From: Amanda Scholes on behalf of Planning.Responses
Sent: 30 November 2017 10:01
To: Planning Scanning
Subject: FW: FAO Mr D Easton: Highways England response - LY/25/17/PL Roseland, The Causeway, Arundel, BN18 9JL.

Application No: LY/25/17/PL

Site: Roseland, The Causeway, Arundel, BN18 9JL.

Proposal: 5 No. residential units (resubmission following LY/9/17/PL).

Construction Method Plan - 1:100 @ A1

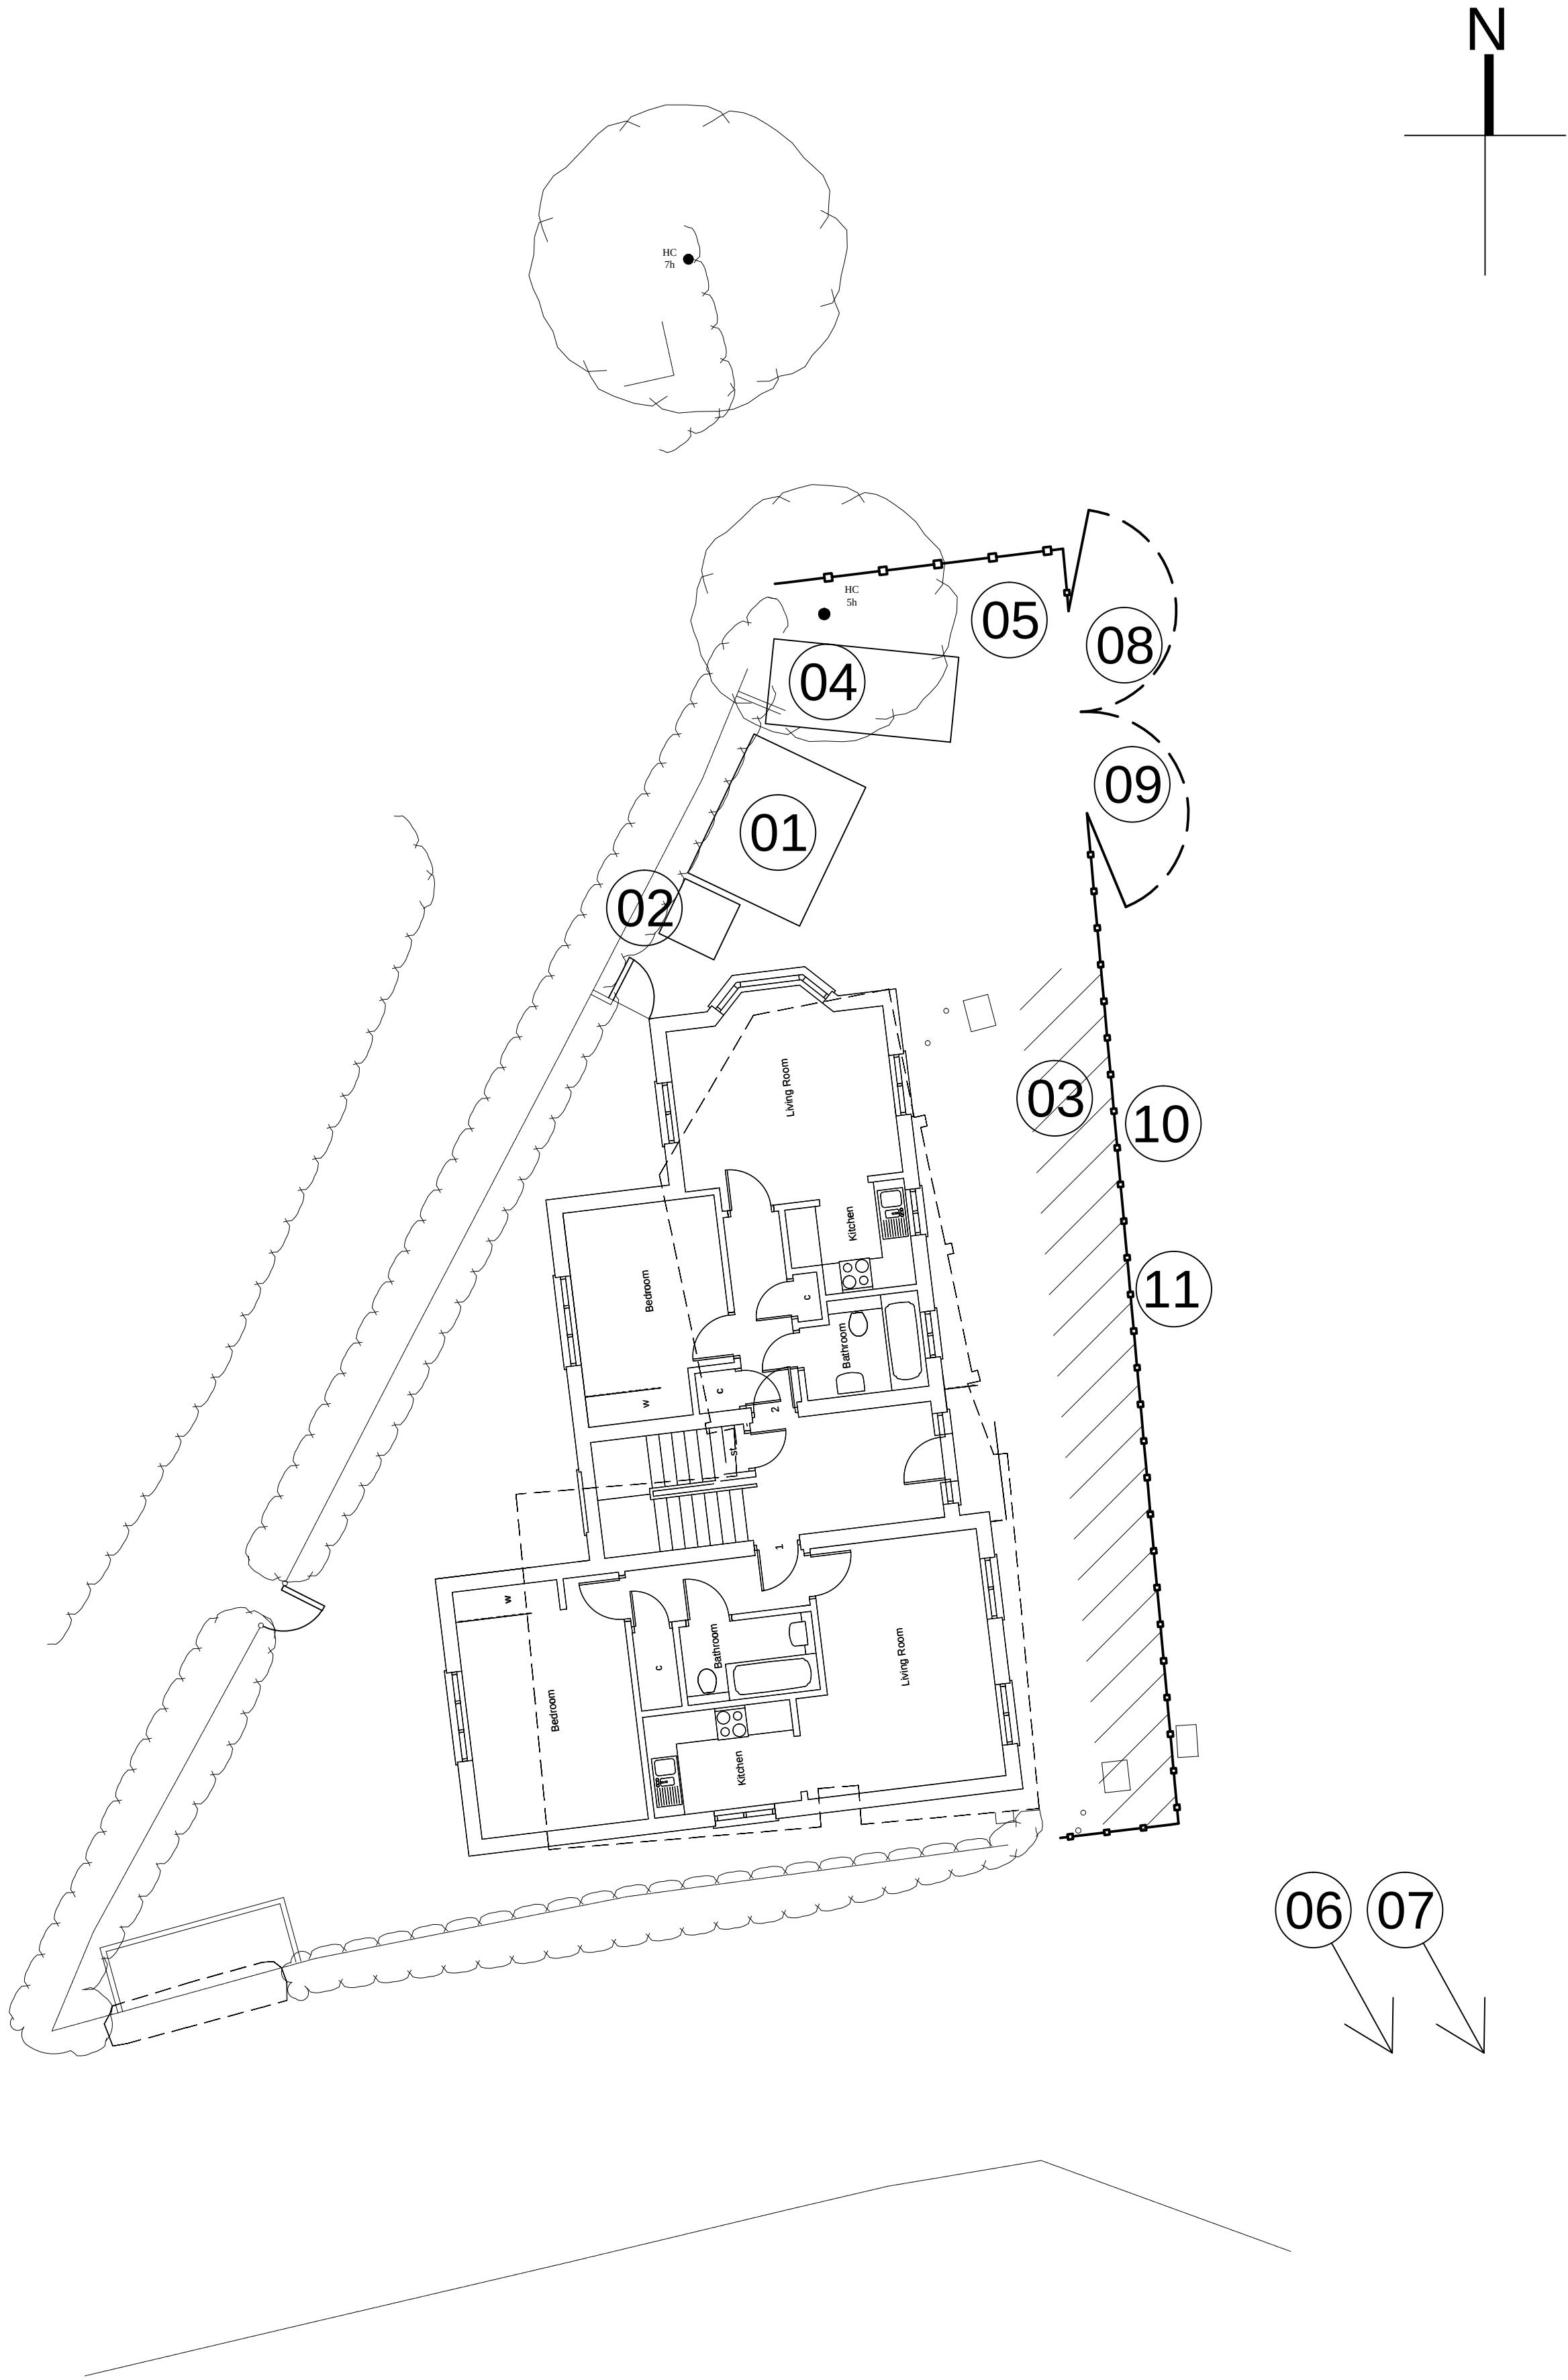
- The Construction Management Plan drawing states "*Wheel washing location – if deemed necessary*" and page 9 of the Construction Management Plan documents states "*No wheel wash necessary, however if necessary a wheel wash will be provided*". We consider that the provision of a wheel wash is necessary, and thus all documents should be updated as such.

- Page 7 of the Construction Management Plan document shows vehicles travelling north of the A27 turning left into the site. We are concerned that this manoeuvre would not be possible for Heavy Goods Vehicles (HGVs), as it would require them to reverse out onto the A27 to complete the manoeuvre with obvious road safety implications. Accordingly, swept path assessments should be provided to demonstrate that this manoeuvre is possible for all vehicles unimpeded. Otherwise, the document should be updated to show the route for HGVs as continuing to the A27 / The Causeway roundabout to make a U-turn manoeuvre before travelling south on the A27 and turning right into the site.
